**SYDNEY
REGIONAL
DEVELOPMENT
ADVISORY
COMMITTEE**

**PROPOSED MIXED USE COMMERCIAL AND RETAIL DEVELOPMENT
AT 89 GEORGE STREET, PARRAMATTA**

I refer to council's letter of 28 July 2010 (Ref: NCA/3/2010), regarding the above mentioned Development Application referral to the Roads and Traffic Authority (RTA) for comment in accordance with Clause 104 and Column 2 of Schedule 3 of State Environmental Planning Policy (Infrastructure) 2007. The Sydney Regional Development Advisory Committee (SRDAC) considered the traffic impact of this application at its meeting on 11 August 2010.

01 PLAN - BASEMENT 1
SCALE 1:200
5 CARS

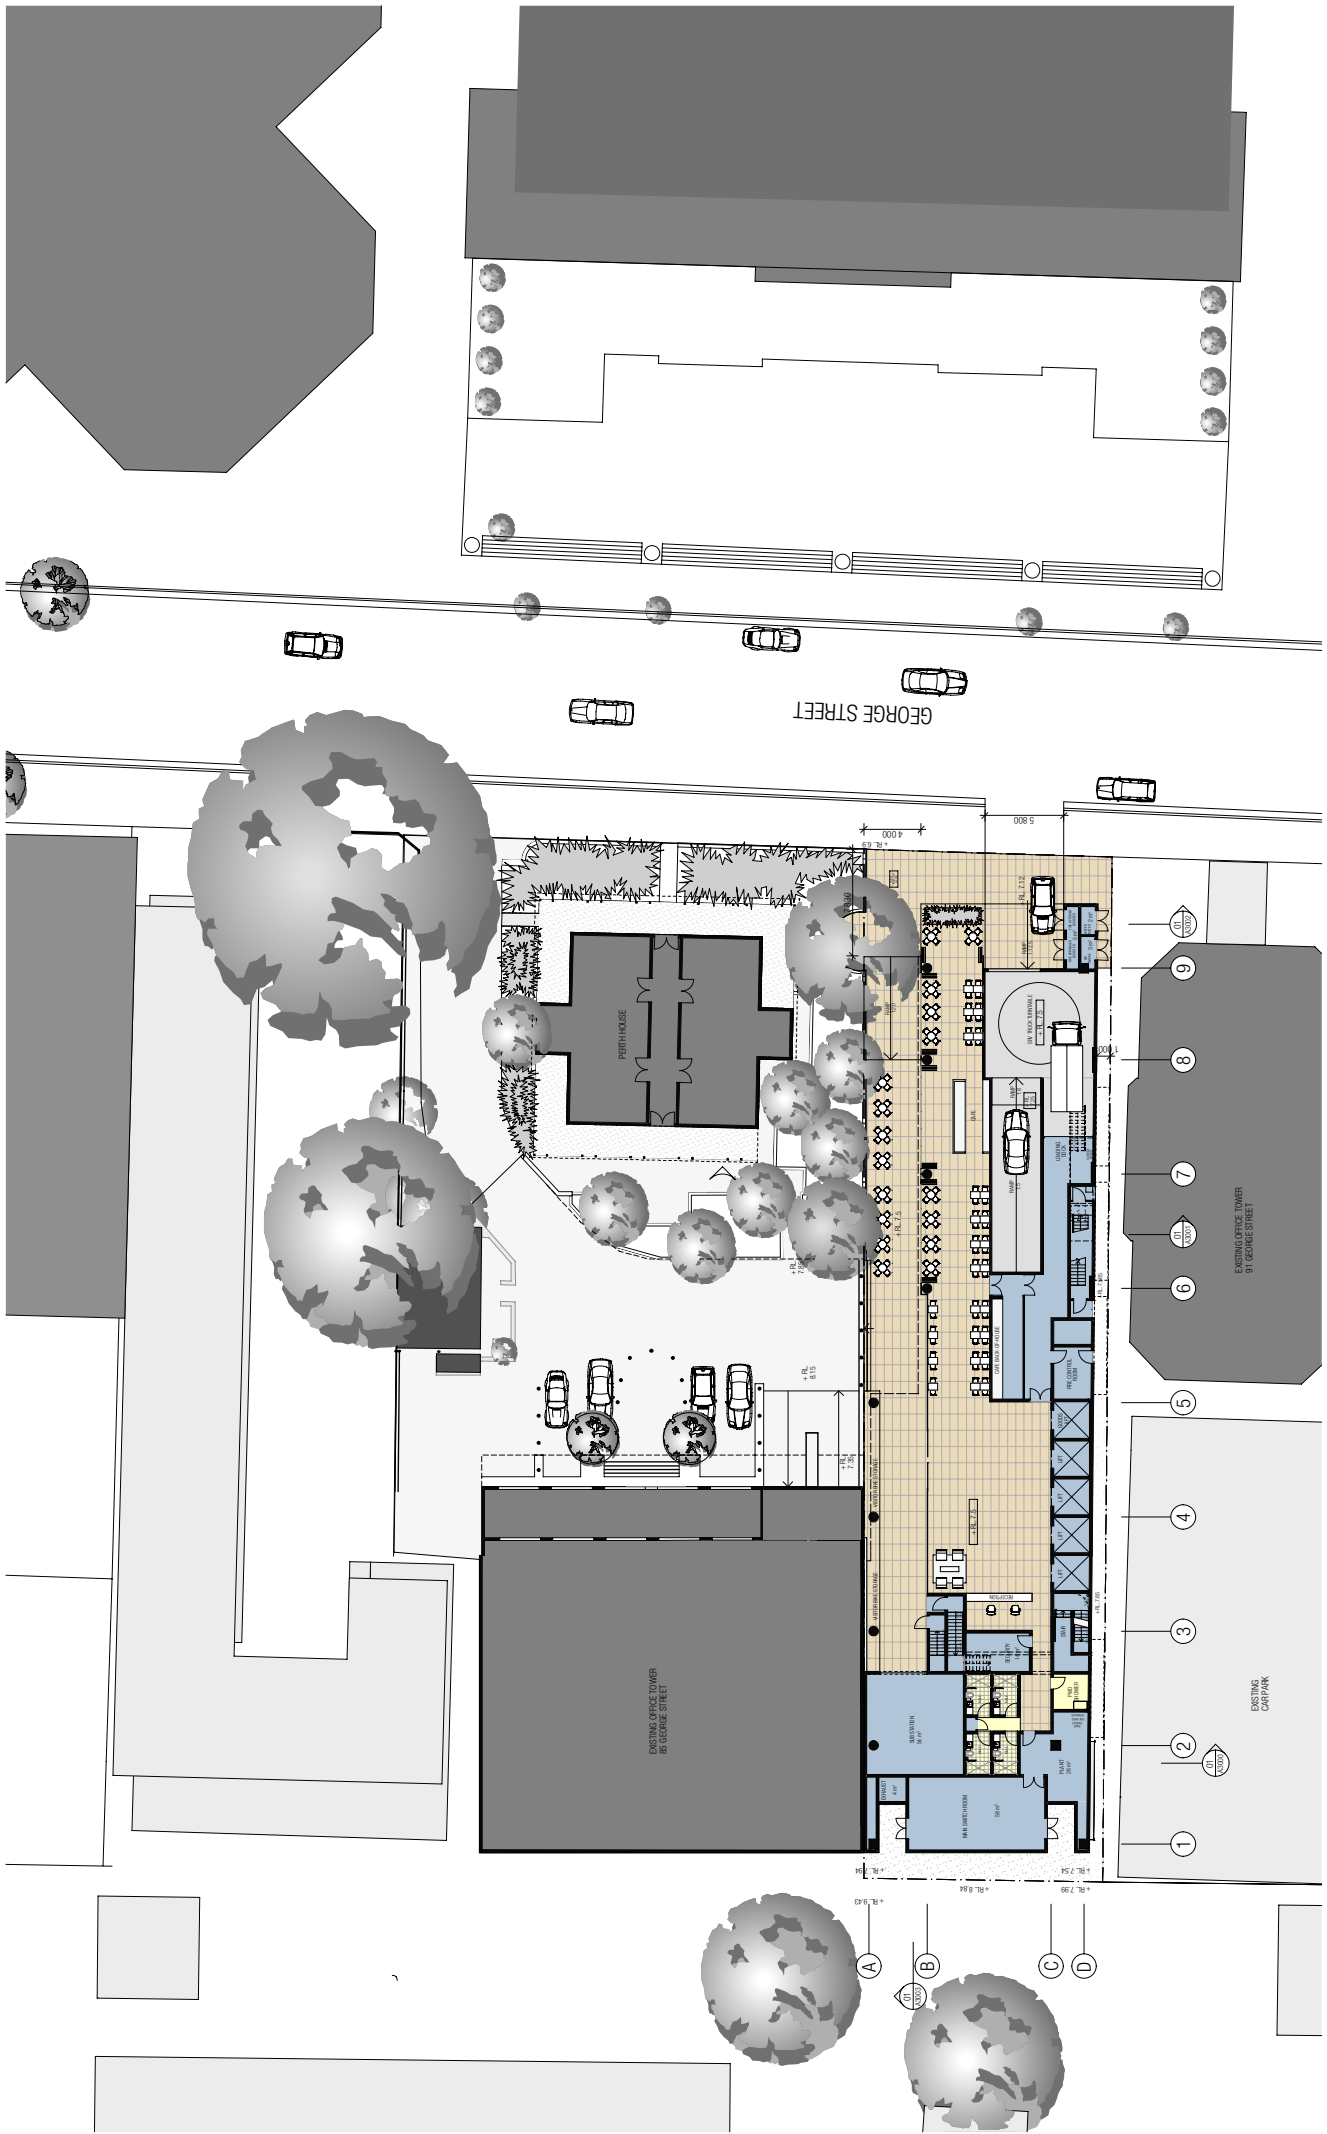
3. Cars should enter and exit the site in a forward direction.
4. The access driveway and ramp to Basement Level 1 should be widened to allow for simultaneous two way movements.
